From: allenfam2004@charter.net
To: [Kelly Bacon \(CD\)](#)
Subject: Carey Mini Storage (CU-20-00003)
Date: Monday, September 21, 2020 10:23:52 AM

I am responding to the notice of application I have received from your office regarding the proposed Carey Mini Storage. My property is adjacent to the proposed development. I strongly object to the proposal as submitted for the following reasons:

# Site Plan

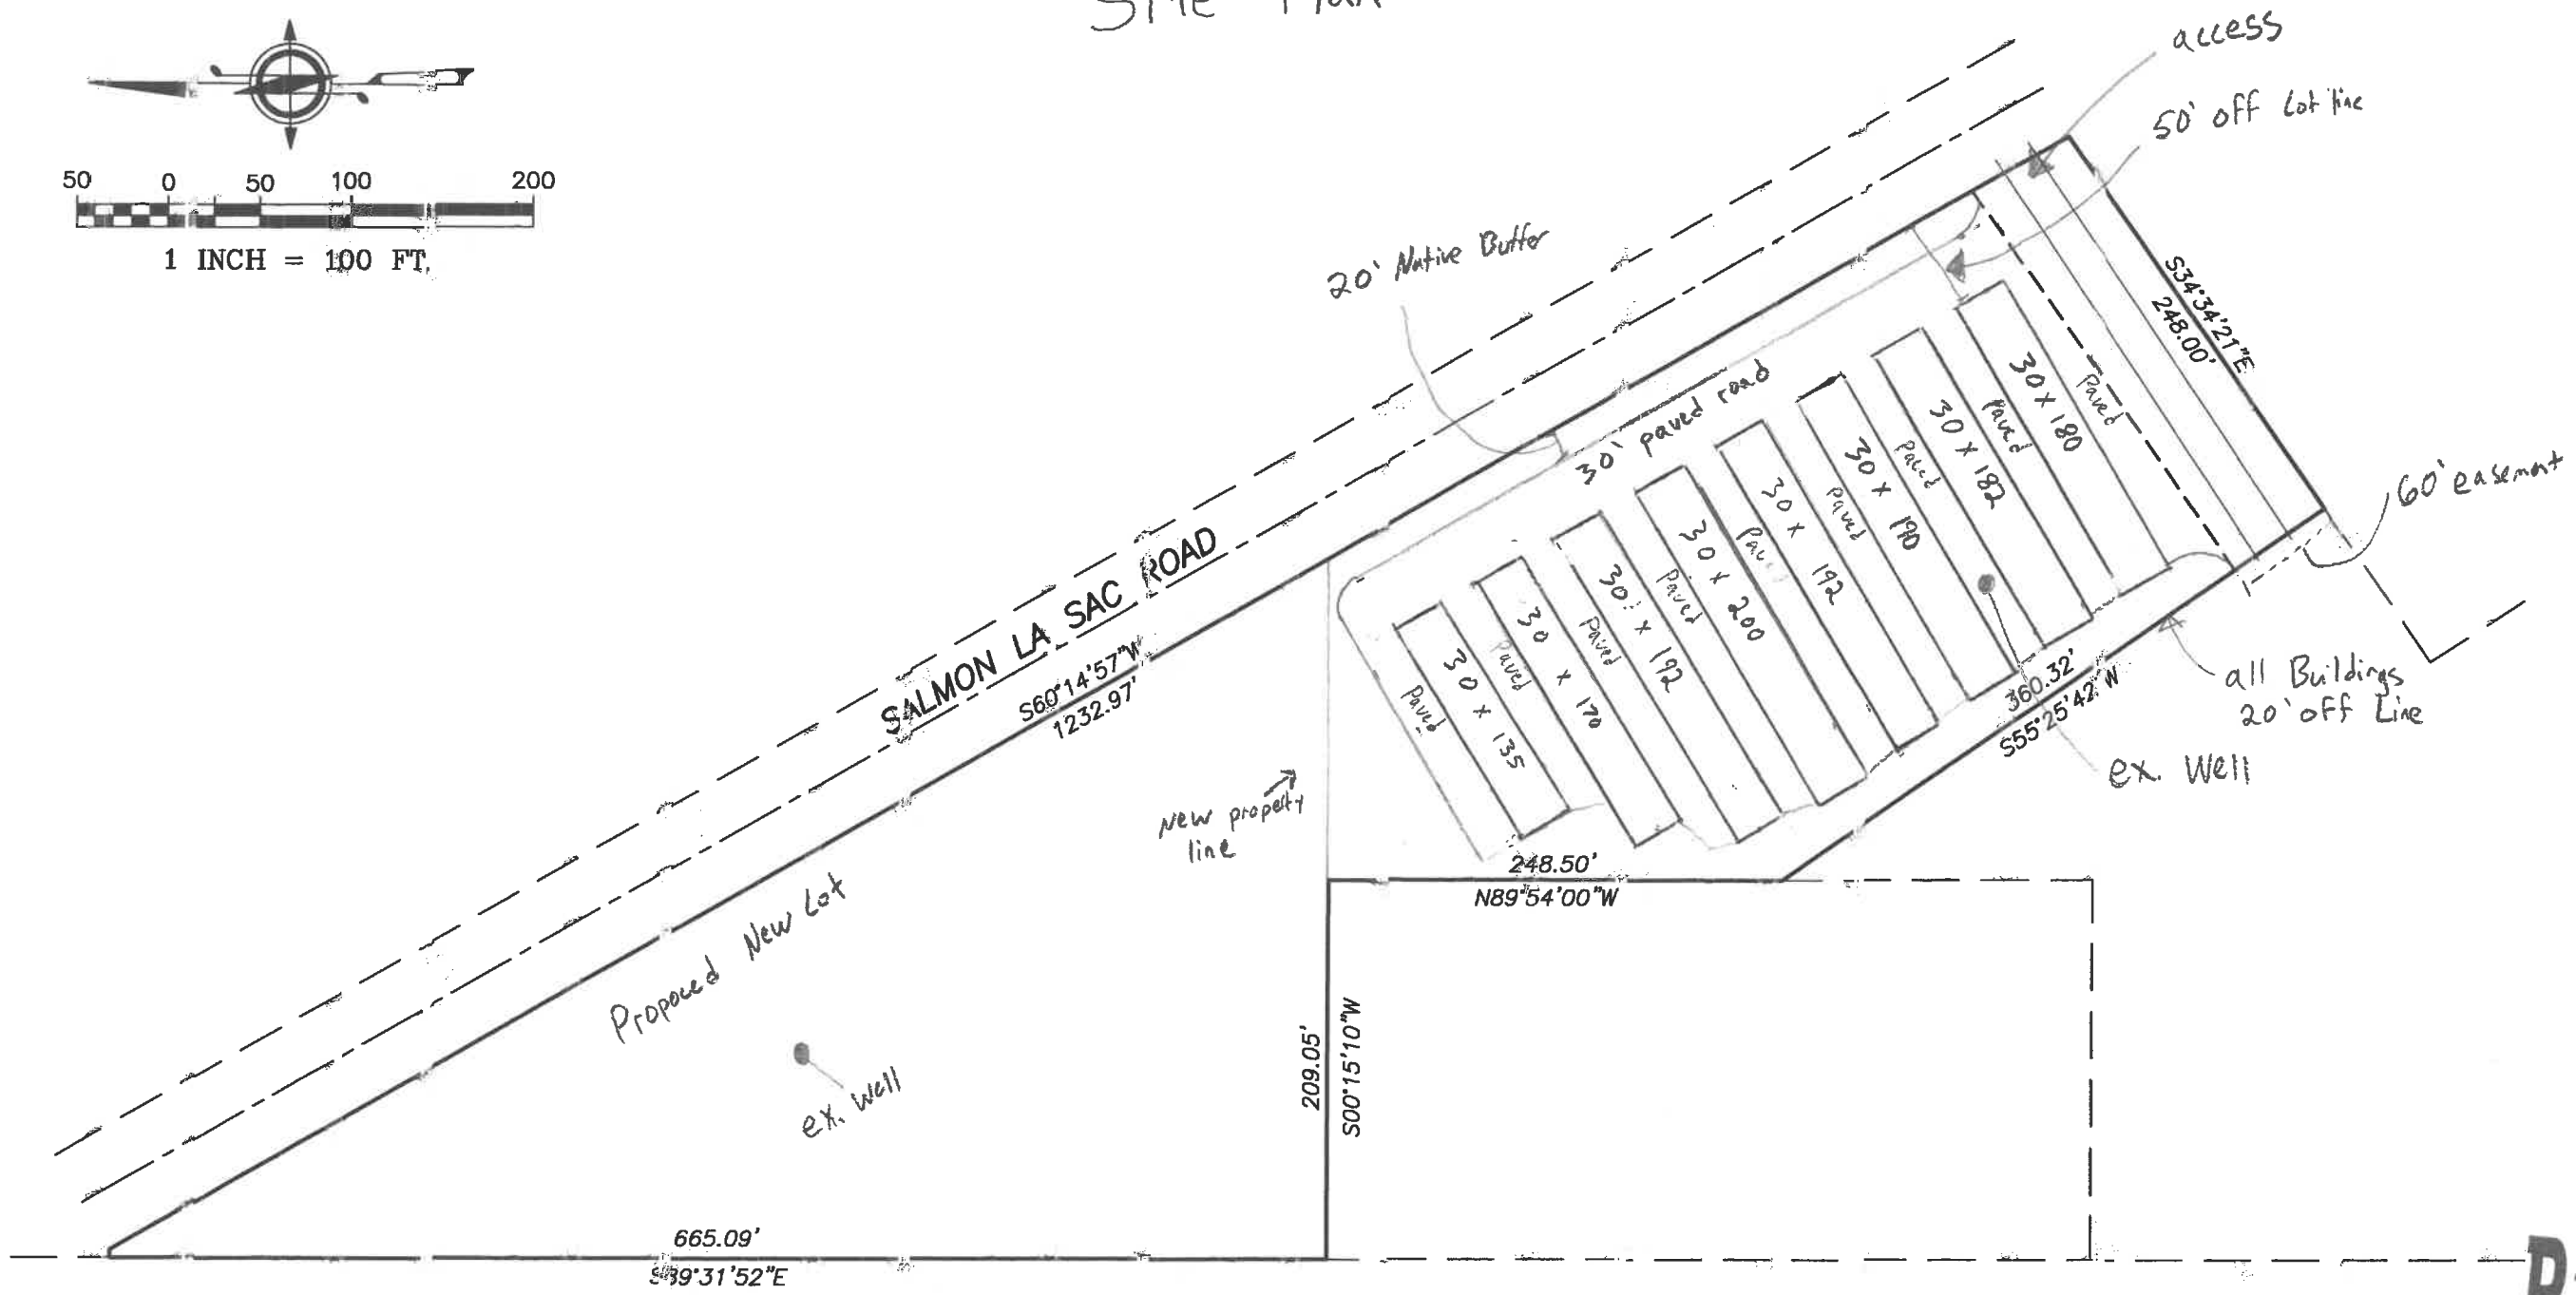
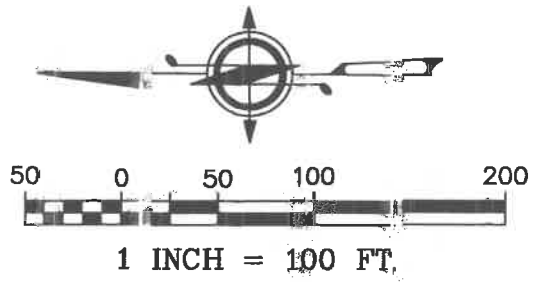
3. Drainage has to be a big concern. The property drains naturally toward the lake and down the canyon, a fact that puts all of the housing downhill at risk. It particularly puts me and my neighbor to the north at risk. It would take a significant natural buffer to minimize the damage and more importantly drainage engineering to slope the slab toward Salmon La Sac road.

4. The site plan is incorrectly drawn. If you look carefully at the county map and the drawing, it is clear the proponents of this project do not understand where my property line lies.

5. The proponents have not adequately expressed how they will mitigate the unsightliness of the project from homeowners near by. It certainly would need to be fenced and hidden by natural foliage. Fencing would also be needed to keep transient customers from coming onto our property. These are nice homes in the vicinity this project. The fencing needs to be esthetically pleasing, not some cyclone metal insult to the neighborhood.
